Reference No:	<b>2025/62/91075/E</b>
Site Address:	15, Woodkirk Gardens, Woodkirk, Dewsbury, WF12 7HZ
Description:	Erection of two storey side extension
Recommending Officer:	Jennifer Booth

**DECISION - REFUSED**

## **OFFICER REPORT**

Drawn	CJA
Date	FEB 2025
Scales	1:100 @ A3
Drawing No.	2511 - 0301 - R02

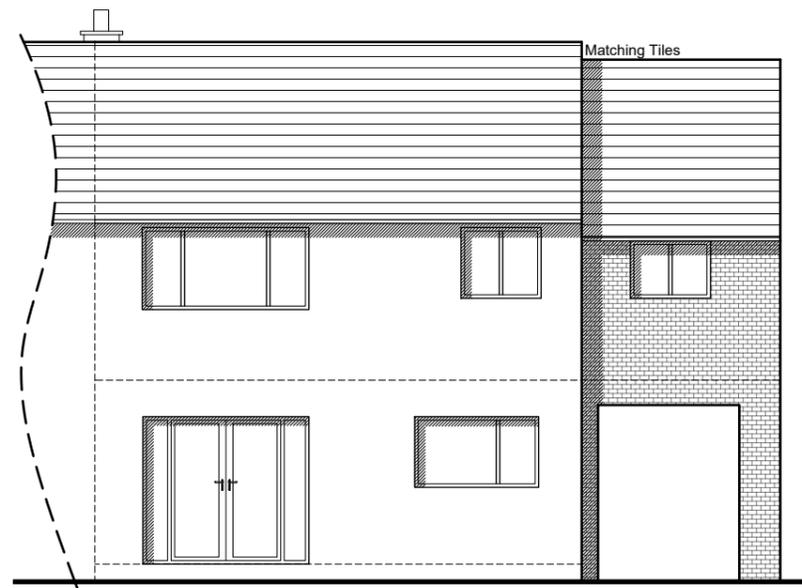
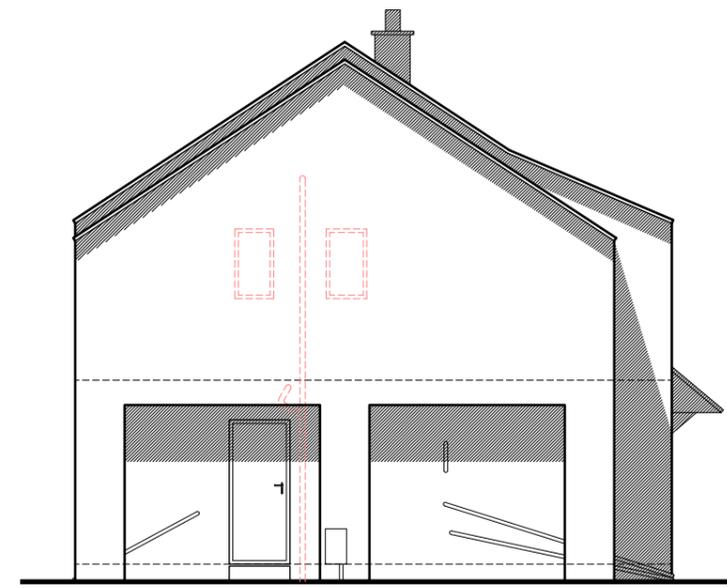
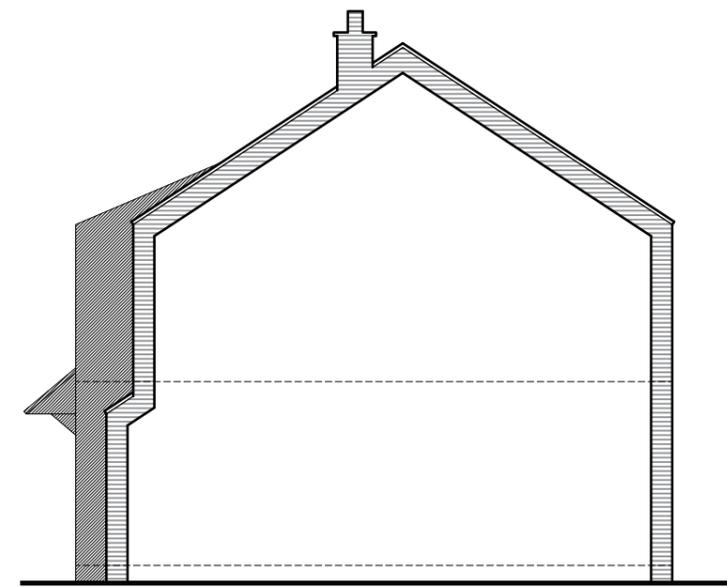
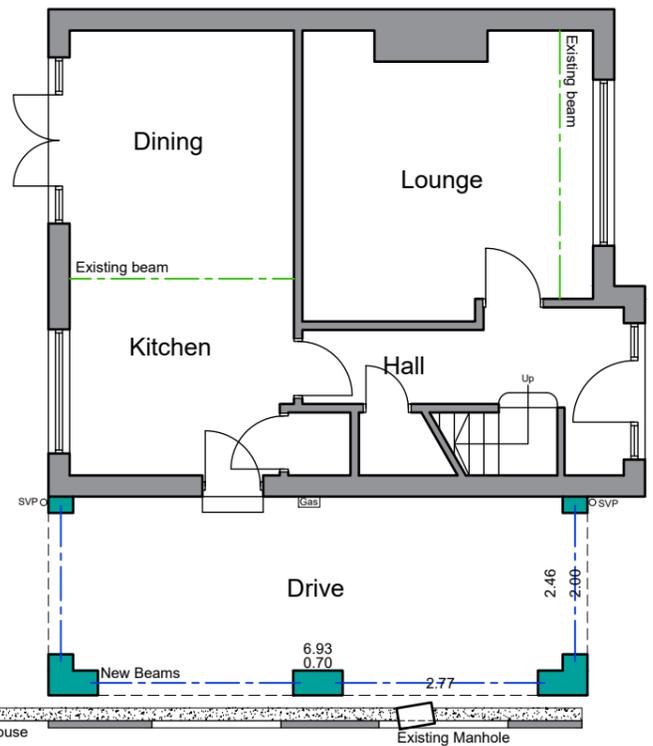
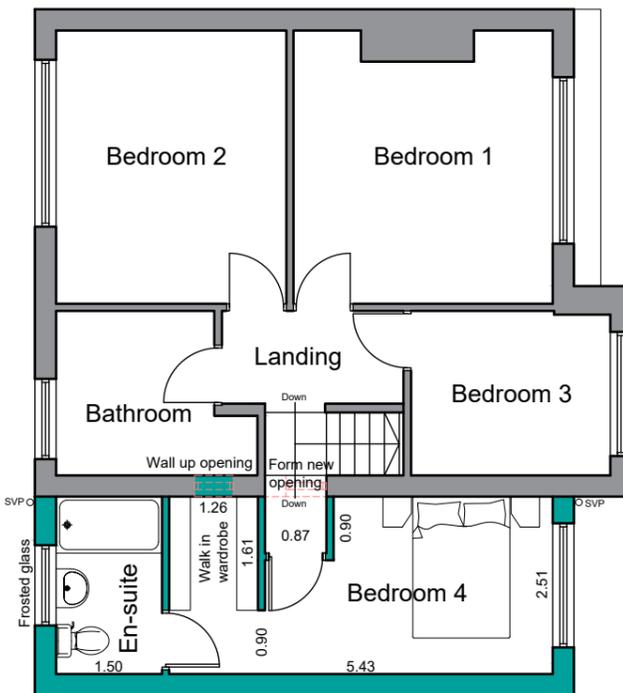
The proposal seeks to construct a two-storey side extension with a 0.8-metre set back from the principal elevation and a corresponding set down to the roofline. While the use of matching materials would ensure visual consistency with the host dwelling, it is noted that the proposed extension would extend up to the shared boundary with no intervening gap. The absence of a physical separation between the extension and the boundary would erode the sense of space between dwellings, which is a characteristic feature of the street scene. Although it is acknowledged that there are a limited number of similar side extensions within the locality, these were granted prior to the adoption of the current House Extensions and Alterations SPD and, as such, are not considered to establish a precedent nor materially alter the character of the

area. The proposal would therefore be contrary to the guidance within the SPD which seeks to maintain visual separation between properties to preserve the spacious and open character of the streetscape.

The proposed two-storey side extension, by virtue of its siting up to the boundary with no intervening gap, would result in an unacceptable loss of visual separation between dwellings. This would diminish the sense of space and be harmful to the character and appearance of the street scene. To permit the proposals would be contrary to Policy LP24 of the Kirklees Local Plan, KDP1 & KDP2 of the House Extensions & Alterations SPD and Chapter 12 of the National Planning Policy Framework.

1. The proposed two-storey side extension, by virtue of its siting up to the boundary with no intervening gap, would result in an unacceptable loss of visual separation between dwellings. This would diminish the sense of space and be harmful to the character and appearance of the street scene. To permit the proposals would be contrary to Policy LP24 of the Kirklees Local Plan, KDP1 & KDP2 of the House Extensions & Alterations SPD and Chapter 12 of the National Planning Policy Framework.

The proposed extension would be constructed up to the shared boundary which would result in the loss of the sense of space between the dwellings, contrary to the House Extensions & Alterations SPD. Amended plans have not been sought.
